MECKLENBURG COUNTY
Park and Recreation Department

MEMORANDUM

DATE: May 30, 2008

RE: Rezoning Petition # 2008-053 Whitehall Corporate Center (overland connector)

ARROWOOD ROAD  
F - F' Cross-Section

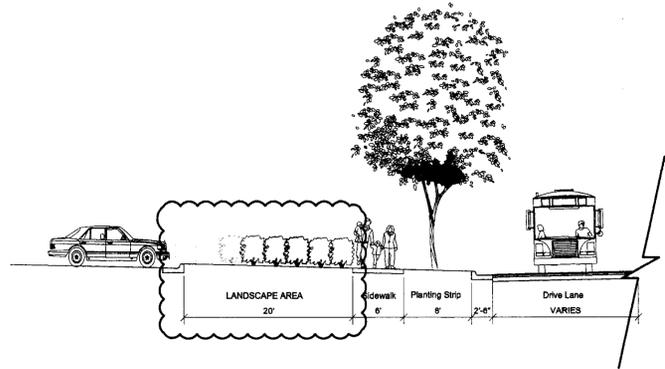
The petitioner has shown an 8' planting strip and a 6' wide sidewalk along Arrowood Road on Sheet L3 of 5 dated 5/16/08. MCPR appreciates that the petitioner is willing to provide an 8' wide planting strip along Arrowood Road. MCPR further requests that the

petitioner increase the width of the sidewalk to 8' from the 6' width shown. The overland connector is an important part of the Mecklenburg County Greenway System. MCPR has secured CDOT support for this request.
